Re: Stationary Noise Cover Letter

Sysco Tannis - 390 Stevenage Drive, Ottawa GWE File No.: 18-121 – Cover Letter R1

This letter describes how we have addressed the peer review comments prepared by Stantec and received from John Bernier at the City of Ottawa by e-mail dated May 2, 2019, pertaining to the stationary noise assessment performed for the proposed redevelopment of the Sysco Tannis facilities located at 2390 Stevenage Drive in Ottawa, Ontario. Below is a summary of how each of the comments relating to the noise study have been addressed. The letter sequence below is in reference to each of the lettered comments continued in the e-mail.

FIGURE 3: EXISTING CONDITIONS SOURCE LOCATIONS

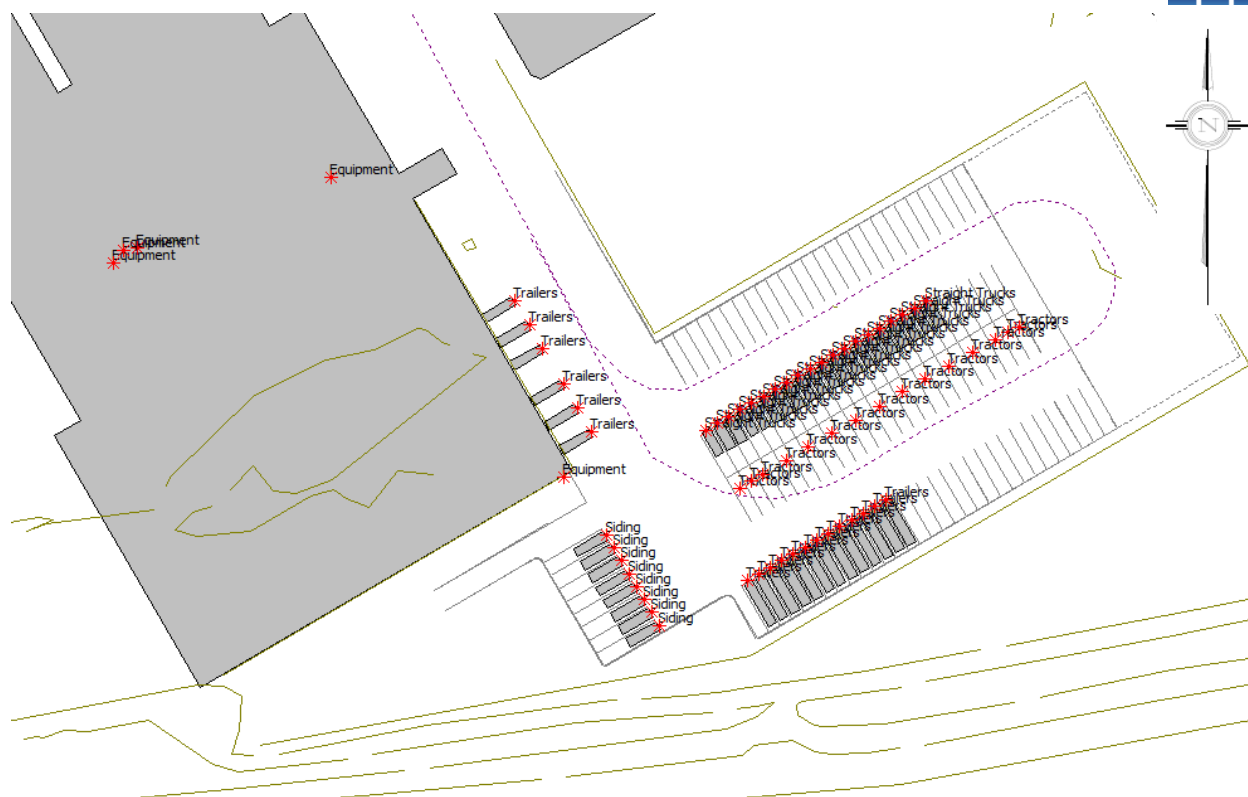
**N**. The report states the existing noise modelling has good correlation with the measured data. However, noise sources for the existing scenario are not listed in the report.

**GWE Response**: Noise sources for the existing scenario are outlined in Section 2.1 and 4.3. Table 2 describes the sound power used for the existing (old) trailers. Note that the old trailers have been taken out of service with the upgrade of the owner's fleet. Source locations are illustrated in Figure 3. The major sources of noise observed during the measurements were reefers and truck movements. The measurements described in Gradient Wind's Noise Monitoring Assessment report, dated January 14, 2019, further support the assumptions in our report that the operations of the reefers of less than 30 min per any one hour is realistic. An extract from Chart 1 shows the fluctuation of sound pressure over the worst case one-hour period, which is more characteristic of a stop/start cycle of the various reefer units.
